Re: ACP Planning Ref: 323742-25

Ecological Response to ACP invitation to respond to submissions relating to the proposed extension to the existing Burial Ground at Drumcliff Burial Ground located at the townland of Drumcliff, Ennis, Co. Clare.

CLIENT: Clare County Council
TITLE: Watermain & Storm Water Sewer Layout

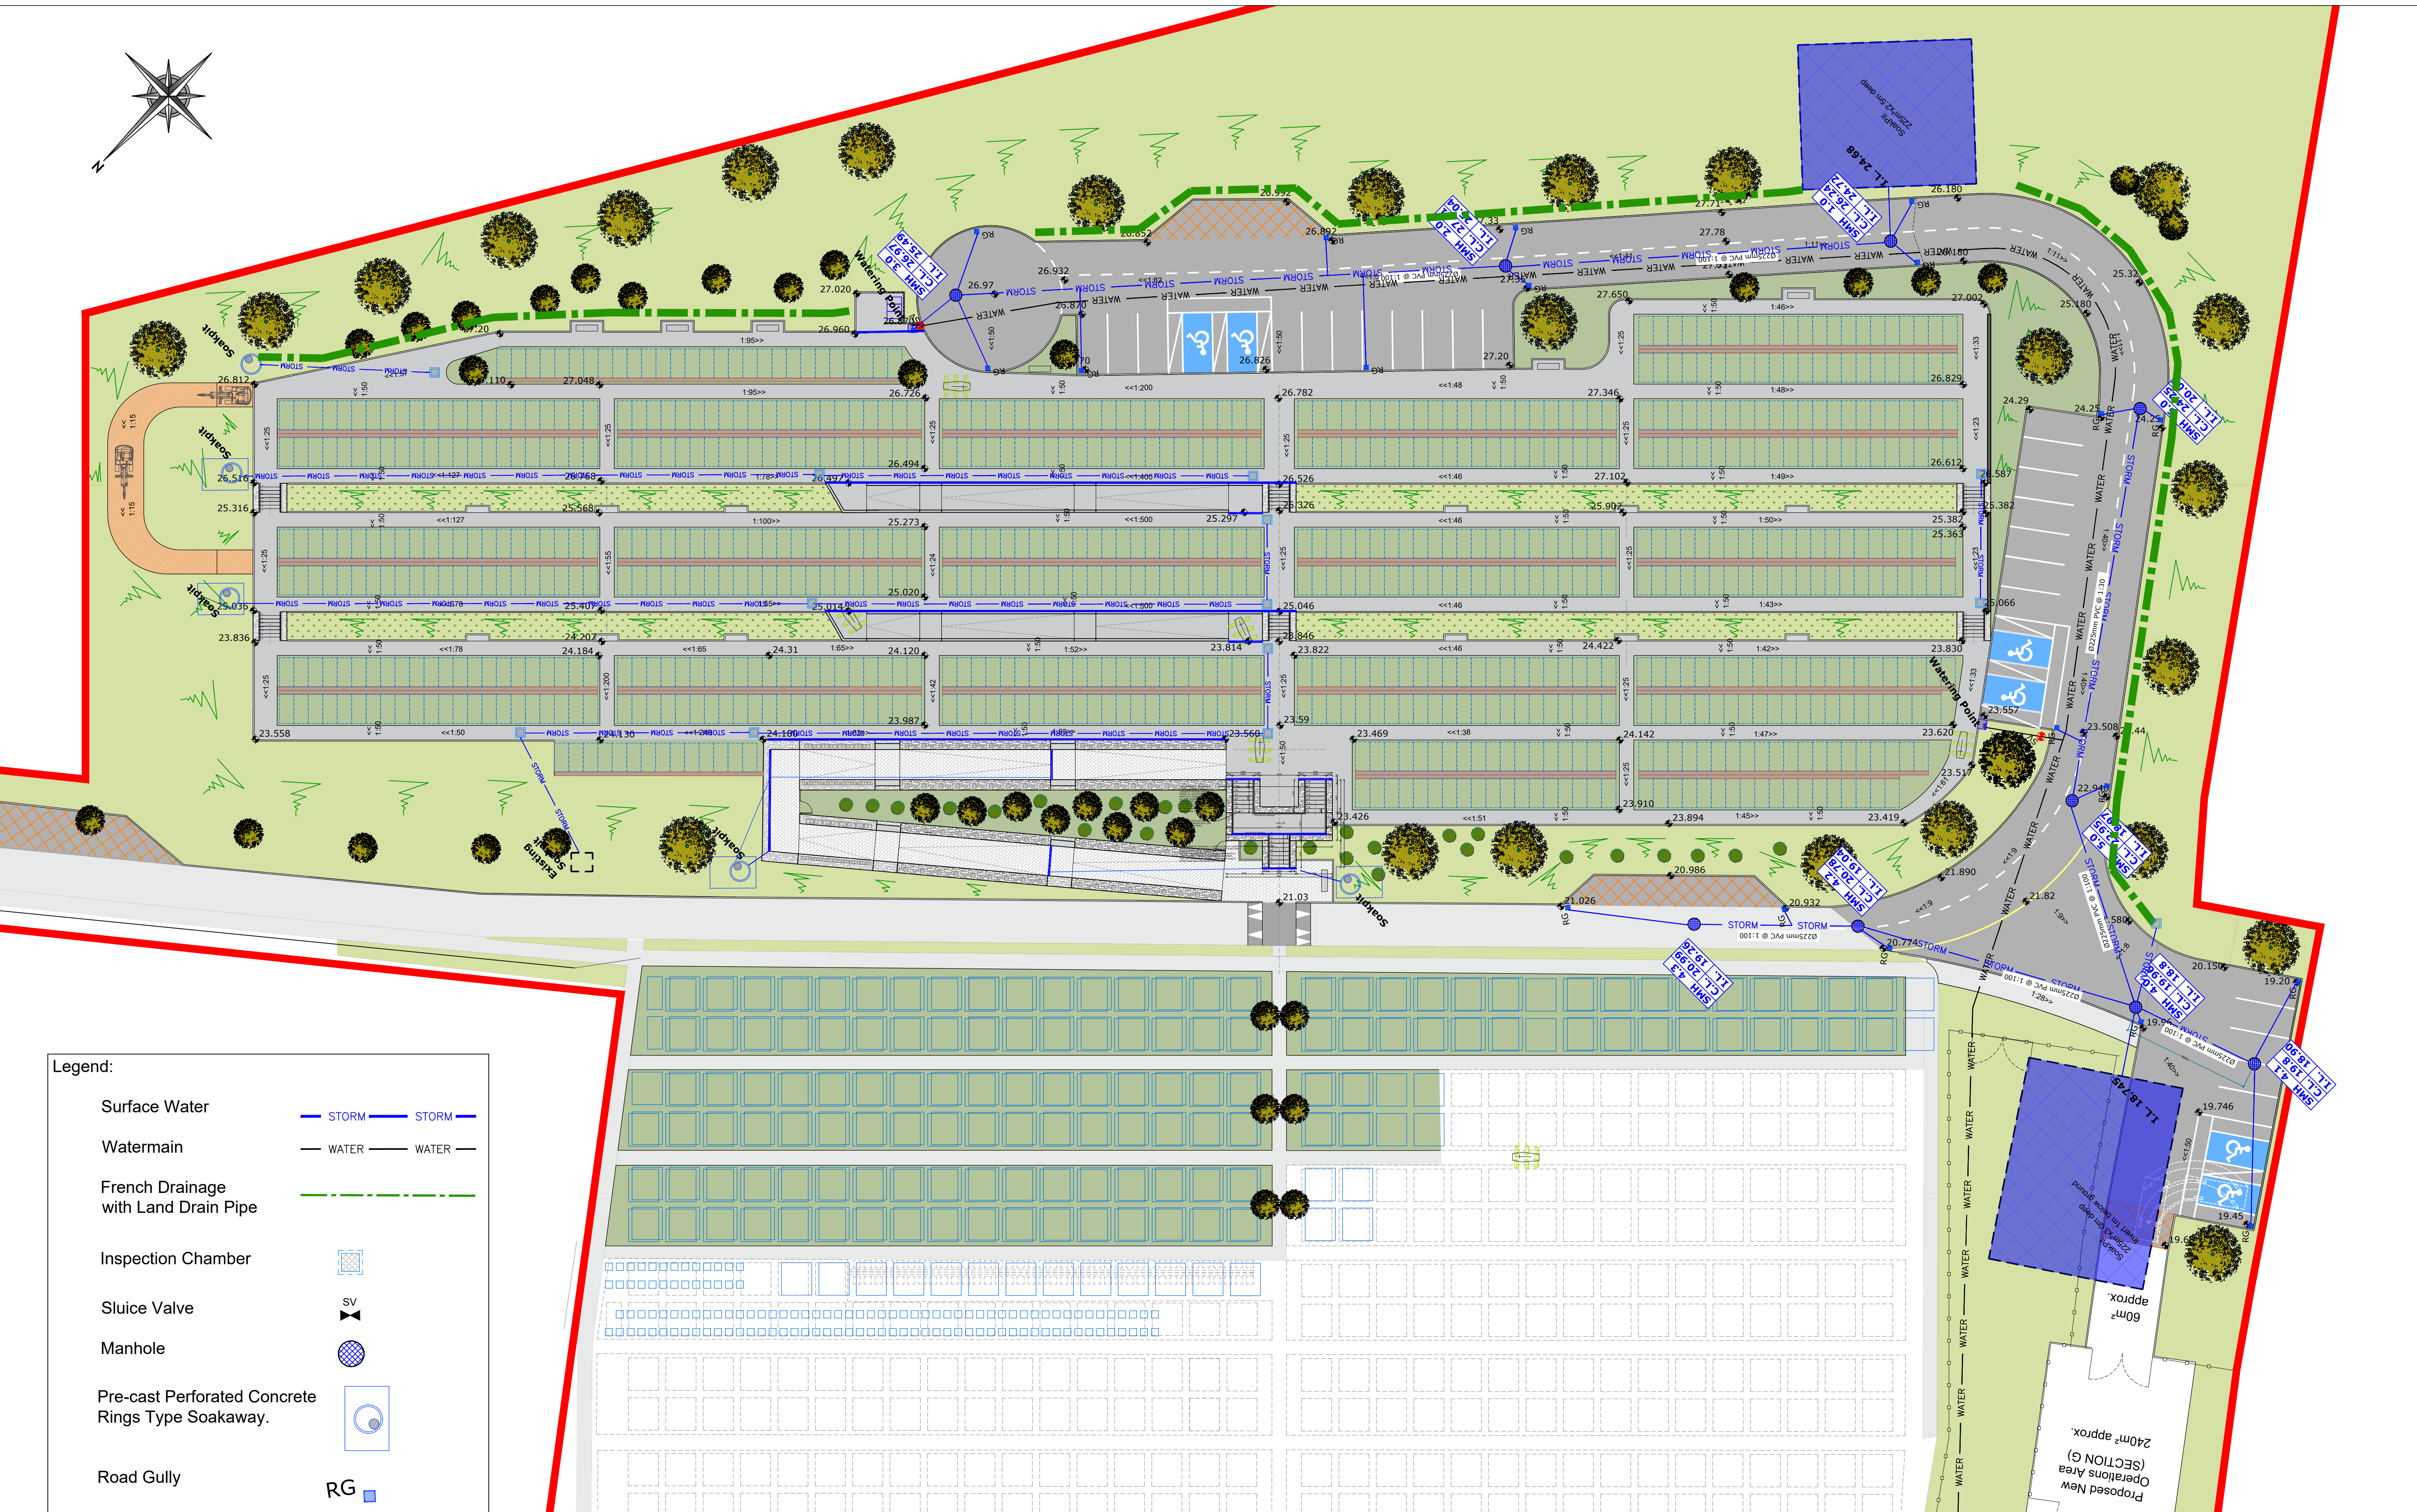
6. MD Comment *“This is a disingenuous assessment in a karst environment where surface water and groundwater regularly interact over short distances. Groundwater can regularly re-emerge as surface water and visa versa. “The drainage design incorporated into the proposed development. will ensure that surface water will be collected, treated and retained within the site, with infiltration to ground via 5 no. proposed soakaways”.*

7. There is no assessment of infiltration, potentially directly to the karst conduit, feeding the potable source at Drumcliff Spring.

Altemar Response: *As outlined in the HES Response “Section 4.4.1 of the HES report details the Operational Phase Impact assessment on potential surface water quality impacts from the proposed surface water drainage system. This section specifically lists the Poulacorey karst feature (and associated Drumcliff Spring PWS) as one of 4 no. potential receptors.*

This section goes on to describe the proposed drainage system at the subject site and the drainage measures employed to ensure that there will be no likely negative effects on potential receptors. These measures include:

- *Surface water falling on green (grave) areas will infiltrate into green areas.*
- *Footpaths will be sloped toward adjacent green areas to allow for infiltration. Surface water from footpaths, which does not directly infiltrate to ground, will be collected by aco drains and directed to soakpits.*
- *Surface water from new roadway will generally be served by a french drain with land drain pipe the roadway. A soak pit area will be provided at the lowest point of the drainage run to accommodate any heavy flows of surface water than is not absorbed by the french drain itself.*
- *New gullies serving existing roadway/proposed roadway junction area are served by a soak pit.*
- *Main Pedestrian Access Ramp and stairs with non-porous finish to be accommodated by soak pit.*

As a result of these design measures, the residual effect on the Poulacorey karst feature and Drumcliff Spring PWS was assessed to be a negative, imperceptible, indirect, medium-term, highly unlikely effect on these receptors.
